From: Patel, Uday [mailto:Uday.Patel@lancashire.gov.uk]
Sent: 25 June 2013 09:53
To: planning
Cc: ENV LHS Customer Service
Subject: 3/2013/0476 - Proposed erection of an agricultural livestock building to house dairy cows on cubicals Phase 1 - Higher Highfield farm, Tinklers Lane Slaidburn Lancashire

Planning Application Reference: 3/2013/0476
Grid Reference: 372695 452620
Proposal: Proposed erection of an agricultural livestock building to house dairy cows on cubicals Phase 1
Location: Higher Highfield farm, Tinklers Lane Slaidburn Lancashire

Drawing No: Mas/104/1605/02						Drawn: AJM	
Client: Mr J. Mason							
Date: 08.05.13						Scale: 1:500/2500 @ A3	
Amendments:

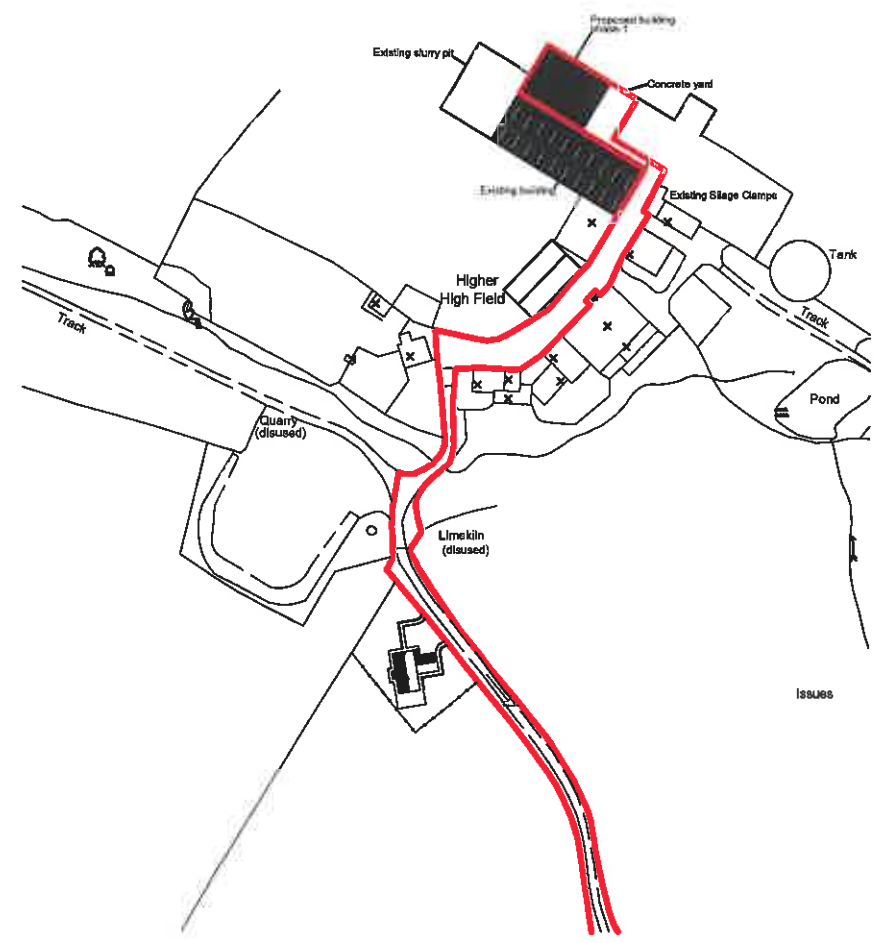
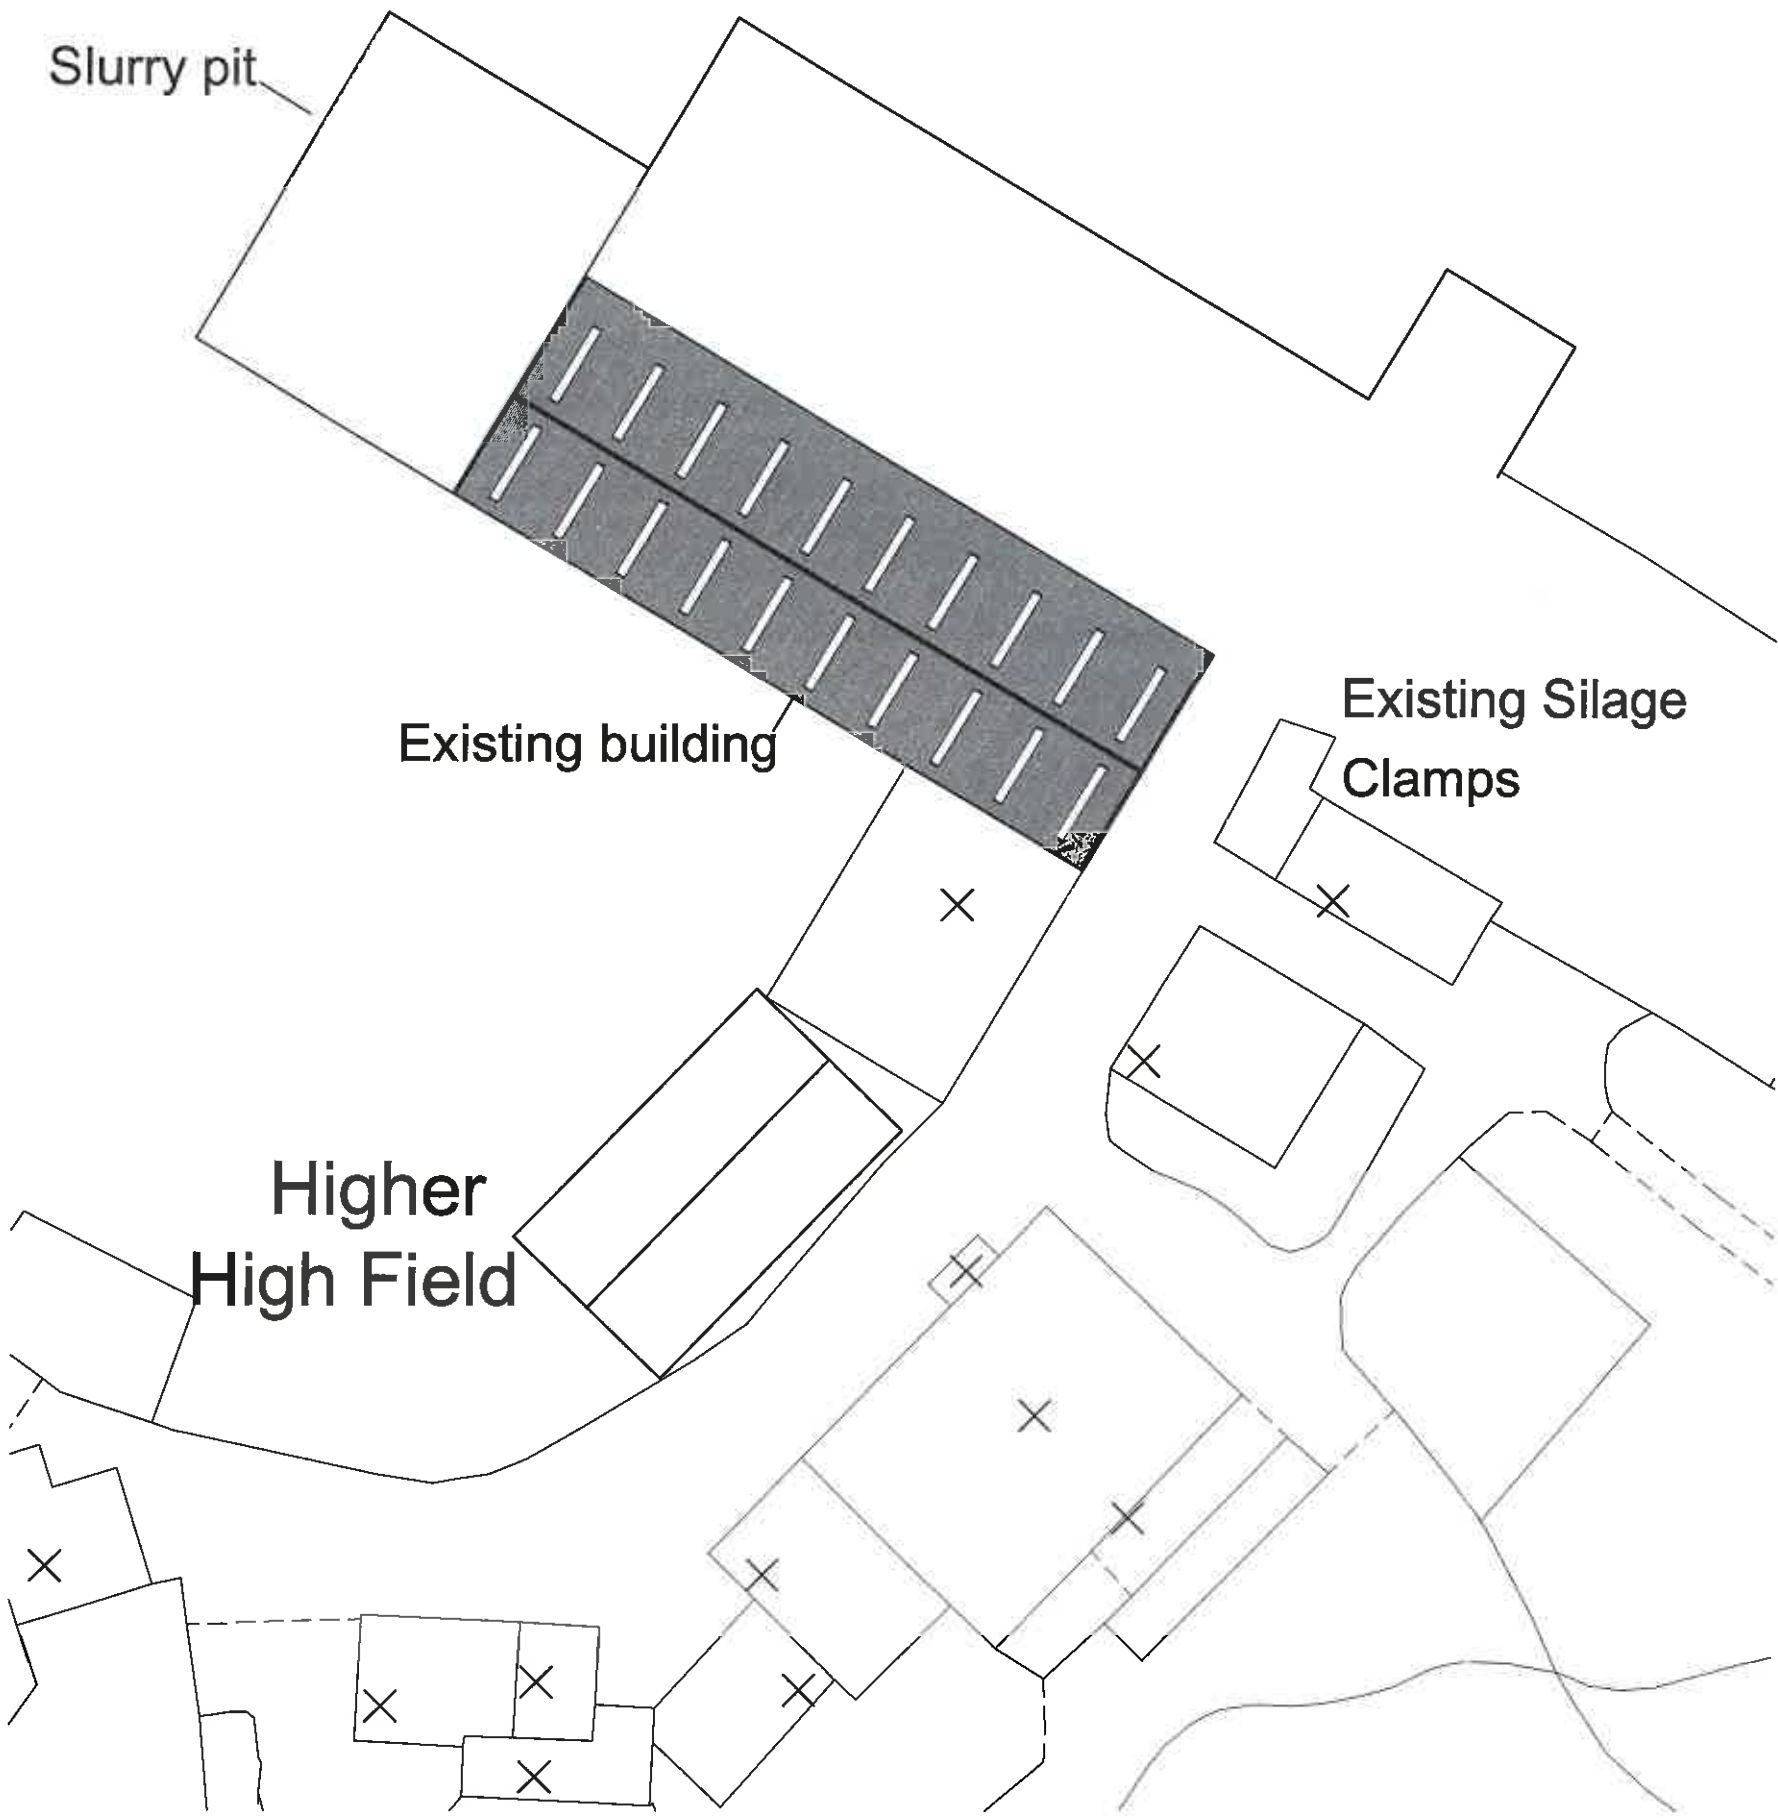
There is an existing access Public rights of way FP16 to the property. The access FP16 forms a junction with Wigglesworth road. There is no change to the existing access to the property. With the proposed development it is anticipated that there will be additional vehicular traffic associated with the new development in terms of vet visits, feed transport vehicles as well as livestock transport vehicles etc. It is anticipated that the current business already uses the existing access to support the such needs and with the proposed development additional vehicular traffic will be catered by the existing infrastructure itself.

It is anticipated that during the time of construction there will be several delivery vehicles as well as construction vehicles traffic on access road FP16 which is a public rights of way.

- Public Rights of Way must not be obstructed during the proposed development. It is the responsibility of the landowner to ensure that the necessary procedures are followed for the legal diversion of the Public Right of Way if this should be necessary. The granting of planning permission does not constitute the diversion of a Definitive Right of Way. If it is

- Should the paths be obstructed during the development or be obstructed after the development has taken place, Lancashire County Council will consider commencing criminal proceedings.
